City of Albuquerque

RE: ENGINEER'S CERTIFICATION FOR 7-11 STORE #57726, HOMESTEAD
HILLS SHOPPING CENTER, (D-11/D9C), SUBMITTED FOR CERTIFICATE
OF OCCUPANCY APPROVAL; ENGINEER'S STAMP DATED MAY 20, 1999,
CERTIFICATION DATED FEBRUARY 7, 2000.

***RE: Engineer's Certification Plan for 7-11 Store # 57726, Taylor Ranch Drive (D11/D9C)
Submitted for Certificate of Occupancy Approval, Engineer's Certification Stamp
Dated 12/30/99.***

***RE: Grading and Drainage Plan for 7-11 Store # 57726, Taylor Ranch Drive (D11/D9C)
Submitted for Building Permit Approval, Engineer's Stamp Dated 5/20/99.***

GRADING & DRAINAGE PLAN

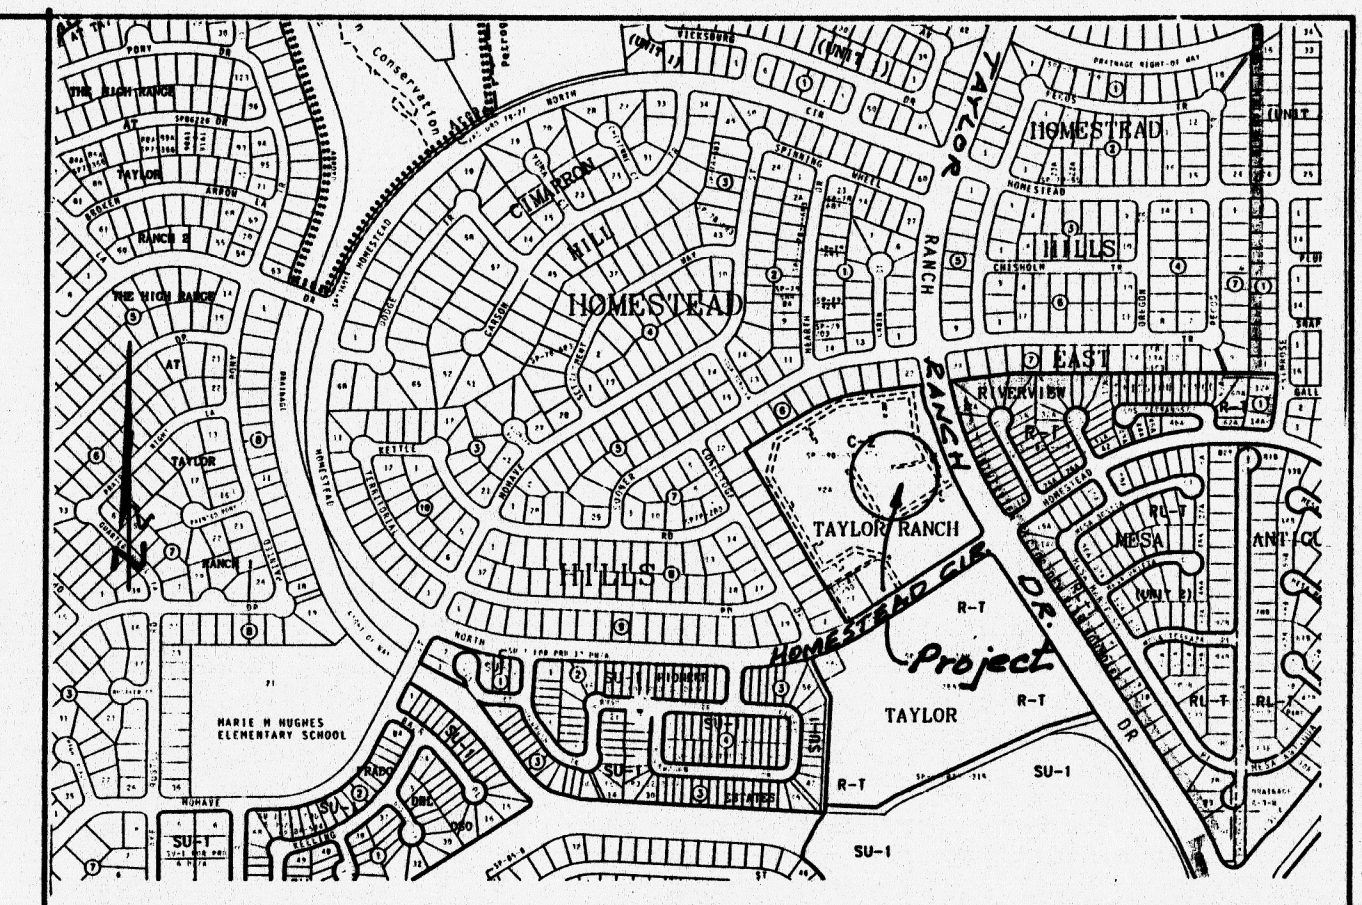
The above referenced plan lacks the required As-Built elevations to determine whether the proposed construction is complete. Therefore, prior to release of the permanent Certificate of Occupancy for this site, please resubmit, providing more information.
